Project:	Highways England Spatial Planning Arrangement 2016-2020	Job No:	60572359/DN052.003
Subject:	Norfolk Vanguard Wind Farm - DMRB Technical Review 2		
Prepared by:	Andrew Beard	Date:	04 January 2019
Checked by:	Andrew Cuthbert	Date:	10 January 2019
Verified by:	John Alderman	Date:	14 January 2019
Approved by:	Andrew Cuthbert	Date:	16 January 2019

Following a DMRB technical review of drawing TP-PB4476-DR012 Rev D0.3 and drawing TP-PB4476-DR015 Rev D0.1 submitted alongside the Environmental Statement and supporting documents prepared by Royal Haskoning DHV (RHDHV), in support of the Norfolk Vanguard Wind Farm proposals, AECOM make the following recommendations.

- 1.3. This Briefing Note (BN06) will review the layouts proposed at the A47 Access A and Access D1 priority junctions with a view to determining whether or not the proposed layouts are compliant with the requirements of the Design Manual for Roads and Bridges (DMRB).

TITLE  
A47 NATIONAL GRID SUBSTATION AC181  
ARTICULATED VEHICLE SWEEP PATH ANALYSIS  
(LEFT TURN IN / LEFT TURN OUT)

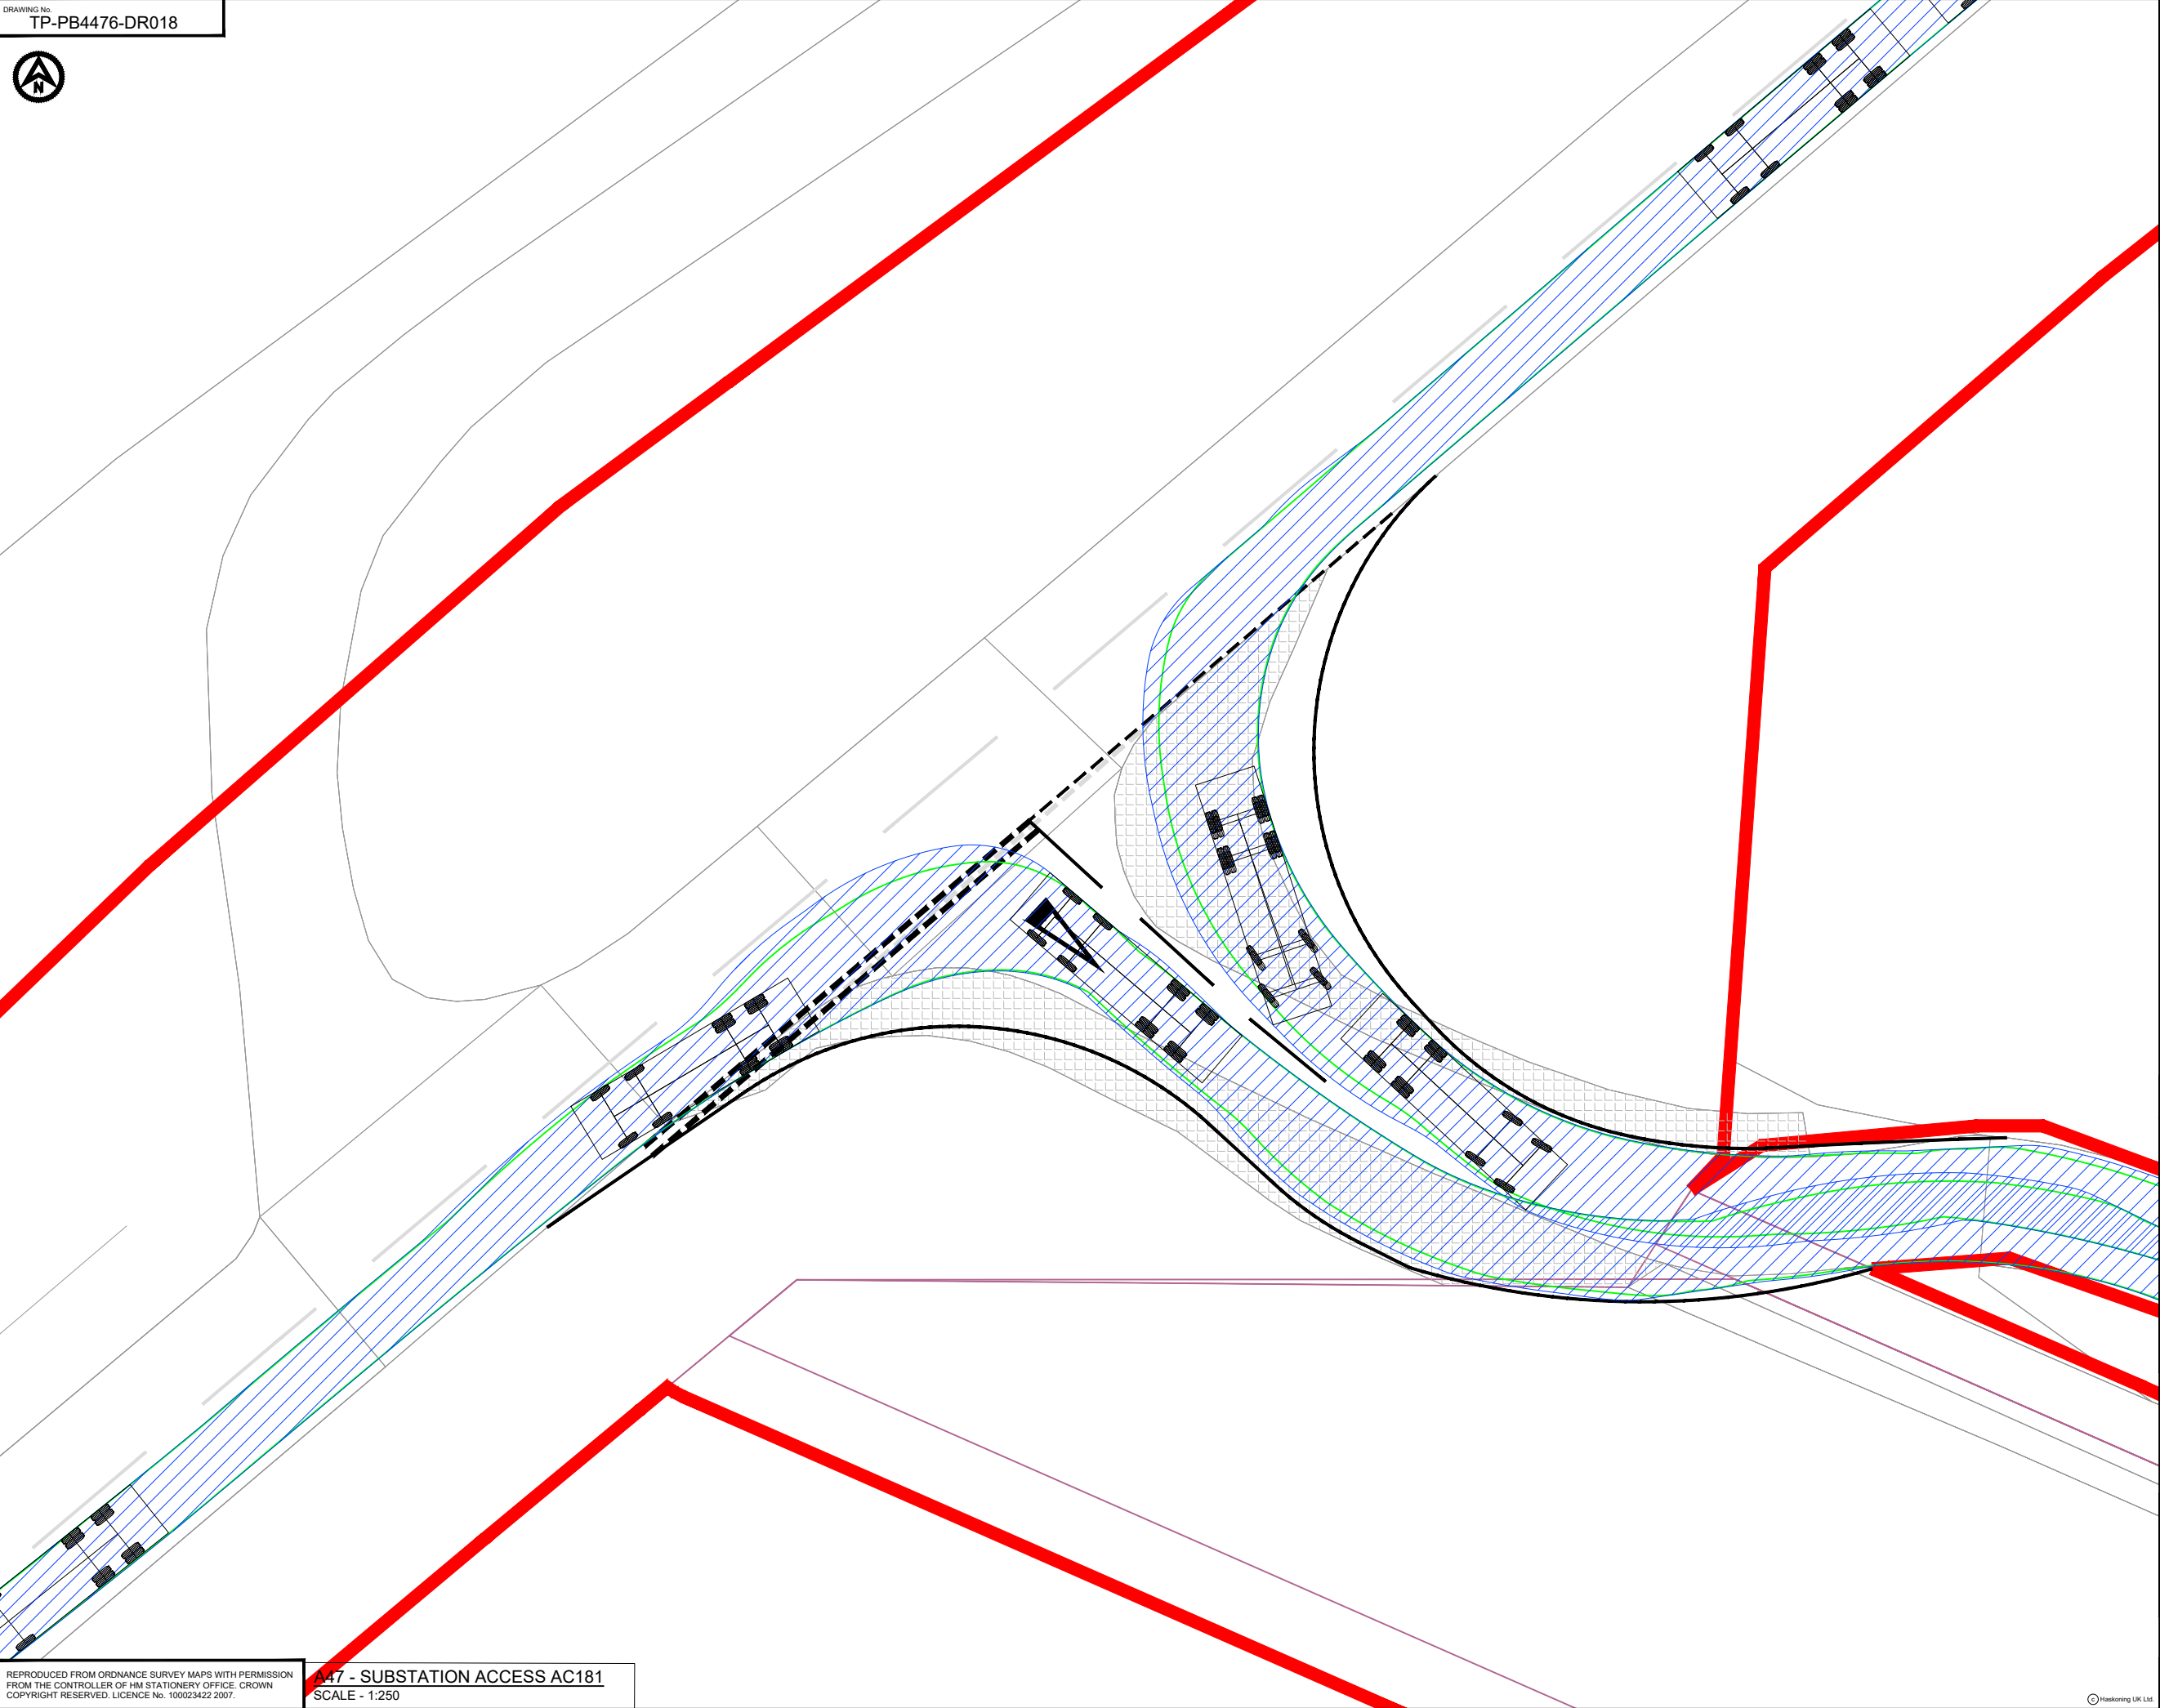
1. A revised access layout should be proposed that would allow vehicles to enter and exit at the same time on a fully paved surface. Vehicular swept path plots should be provided in support of the revised A47 Substation Access A junction layout to demonstrate the ability of an articulated vehicle and large tipper (the Design Vehicles) to negotiate all legitimate turning movements at the junction without overrunning kerb or A47 centre lines. (para. 4.11);
2. The proposed corner radii and exit tapers at Access A should be reviewed in the context of the guidance set out in TD 42 and the grasscrete over-run area extended if necessary to provide the appropriate corner radii and tapers (para. 4.15);

- 4.11. Vehicular swept paths for an 'articulated vehicle' and 'large tipper' are provided in drawing TP-PB4476-DR017 Rev D0.1 and TP-PB4476-DR018 Rev D0.1 respectively. Whilst AECOM note that the swept paths of each of the design vehicles appear to be broadly accommodated within the existing junction layout (including over-run areas), some overrunning of A47 centre lines on the left-turn exit manoeuvre is shown and the swept paths overlap on the access road beyond the immediate junction, raising the risk of conflicts occurring where insufficient width is provided for two vehicles to access and egress the development area simultaneously. Potentially a scenario could occur where a vehicle waiting to egress the access blocks the path of a large vehicle wishing to enter the site, forcing that vehicle to stop on the A47 until the junction access area is cleared and potentially increasing the risk of collisions occurring. **AECOM recommend that a revised access layout is proposed that would allow vehicles to enter and exit at the same time on a fully paved surface. Vehicular swept path plots should be provided in support of the revised A47 Substation Access A junction layout to demonstrate the ability of an articulated vehicle and large tipper (the Design Vehicles) to negotiate all legitimate turning movements at the junction without overrunning kerb or A47 centre lines.**
